Our Ref: EP/70/12/

Alterations & first floor extension, providing a reduced garden room on the ground floor, together with conversion of garage to a gym & 2 new bedrooms, study & bathroom to first floor. Removal of existing pitched roof & replace with lower mono pitched roof

Sandgate House South Strand East Preston Littlehampton

Thank you for your internet representation made on 8th August 2012 which has been recorded as **an objection** with the comments as follows:

1207 SK26
 Sandgate House, East Preston
 Elevations As Proposed - sheet 2
 June 2012
 scale: 1:100

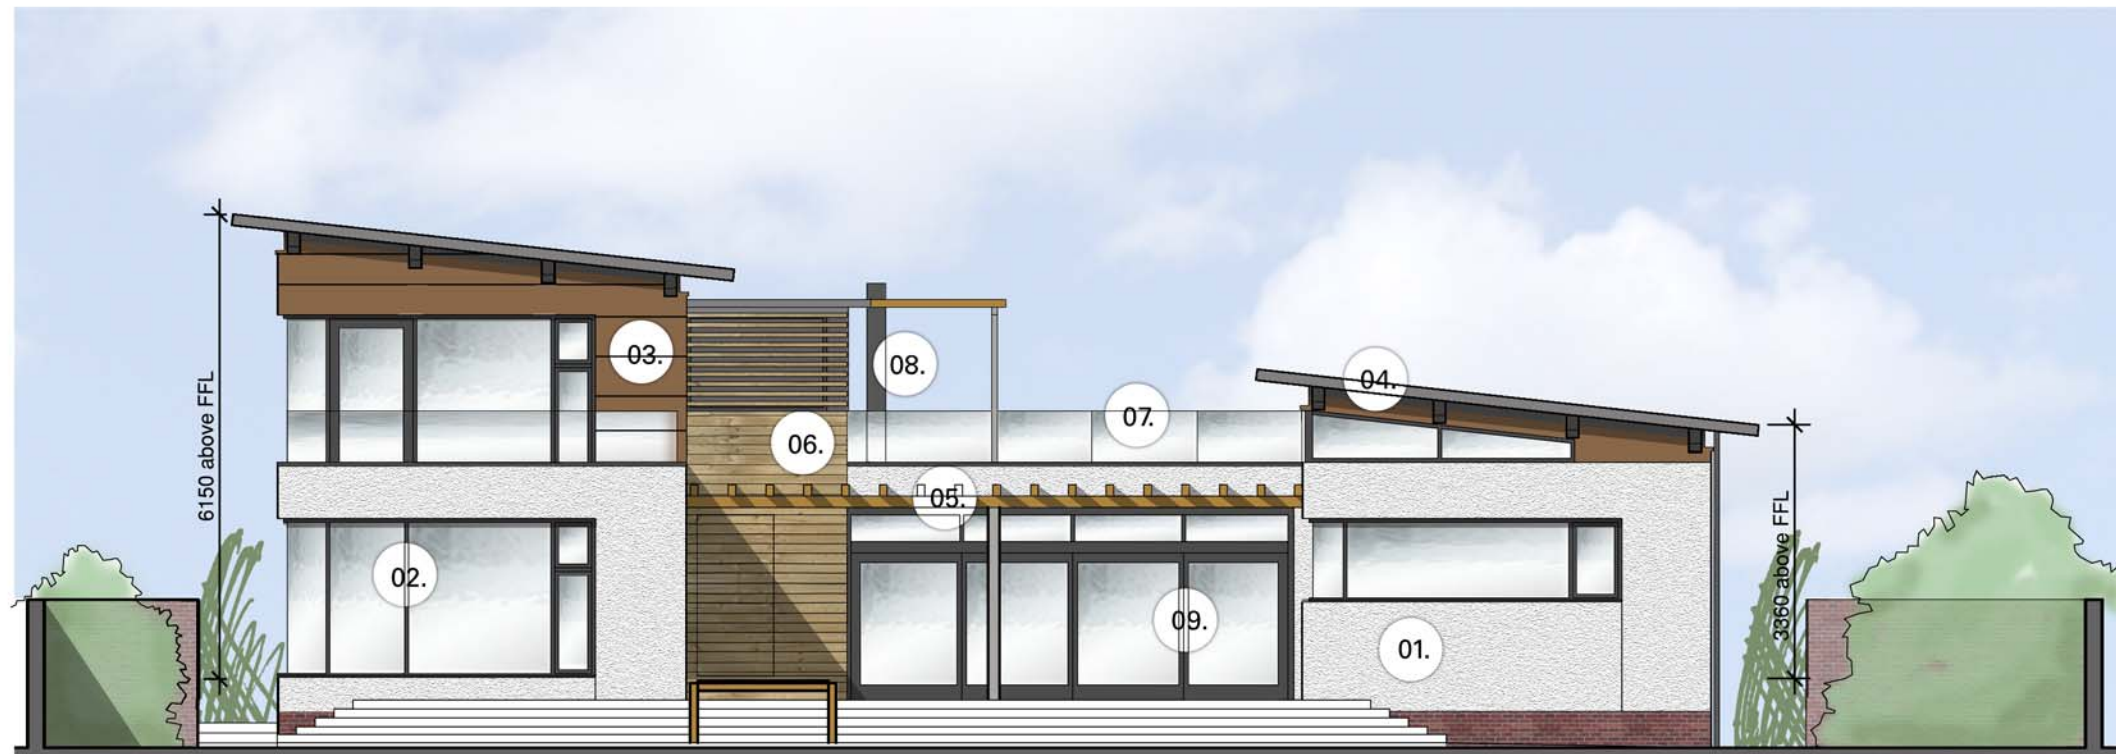
feel that the design of the proposed extension is not sympathetic to the existing building, it is not visually integrated with the existing building and its form and scale are not well-related to the existing building; ☐

it will form the highest part of the building and as such will visually dominate the existing building and not be subservient to it as required. ☐
